From: John Challis [REDACTED]
Sent: 06 November 2018 14:35
To: Charlotte Easton
Subject: Re: Prior Notification Of Works To Tree(s) In A Conservation Area - FP/213/18/TC

Application ref: **FP/213/18/TC**

Location: St Marys Church, Felpham Road, Felpham PO22 7NU

Works proposed: Reduce overhanging branches by 30-40m to 1 No Beech tree within the Felpham Conservation Area

Lime tree - St Mary's Church, Felpham Road, Felpham

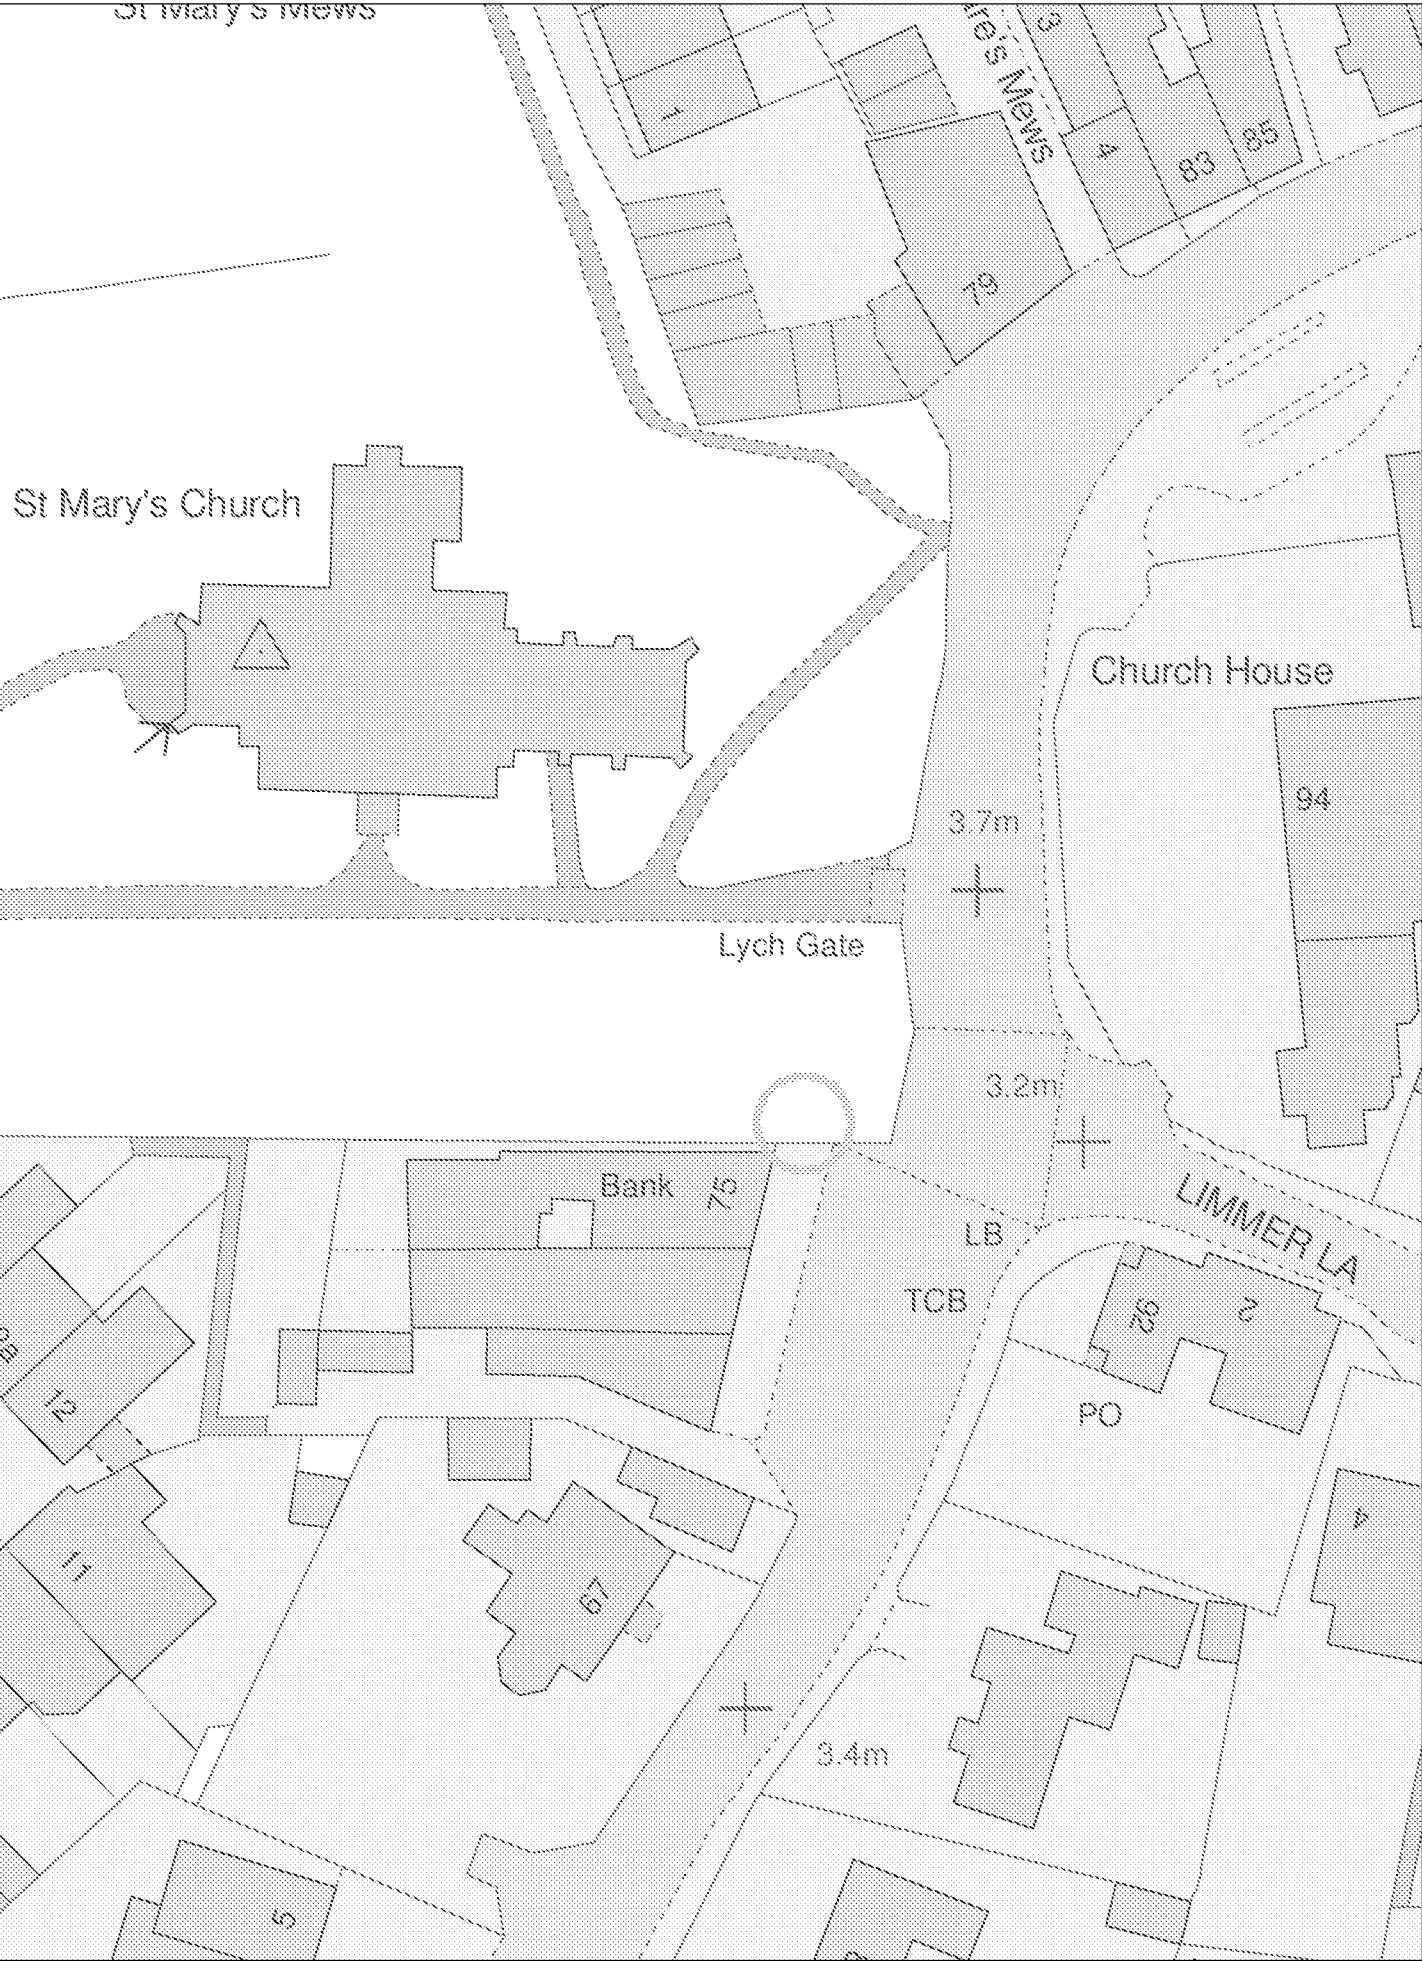
- i) The obvious candidate (tree) for pruning work to address building interference is an early-mature lime, not a beech as described.
- ii) The plan shows a linear tree group, parallel with the main (Felpham) road. The aforementioned lime is one of five that run alongside the building (Deligo sandwich bar/deli) and across the cemetery's south boundary; perpendicular to the main road.
- iii) The work proposal '*reduce overhanging branches by 30-40m*' is possibly an error in translation although an assumed 3-4m clearance would still be excessive and spoil the appearance of this tree.

My advice would be to ask the applicant to revise their Notice/or withdraw it – so as to accurately describe the position of the tree and propose a more sensitive work specification, as follows:

Prune back branches to achieve a maximum of 1.5m building clearance and 6m overhead clearance across property frontage.
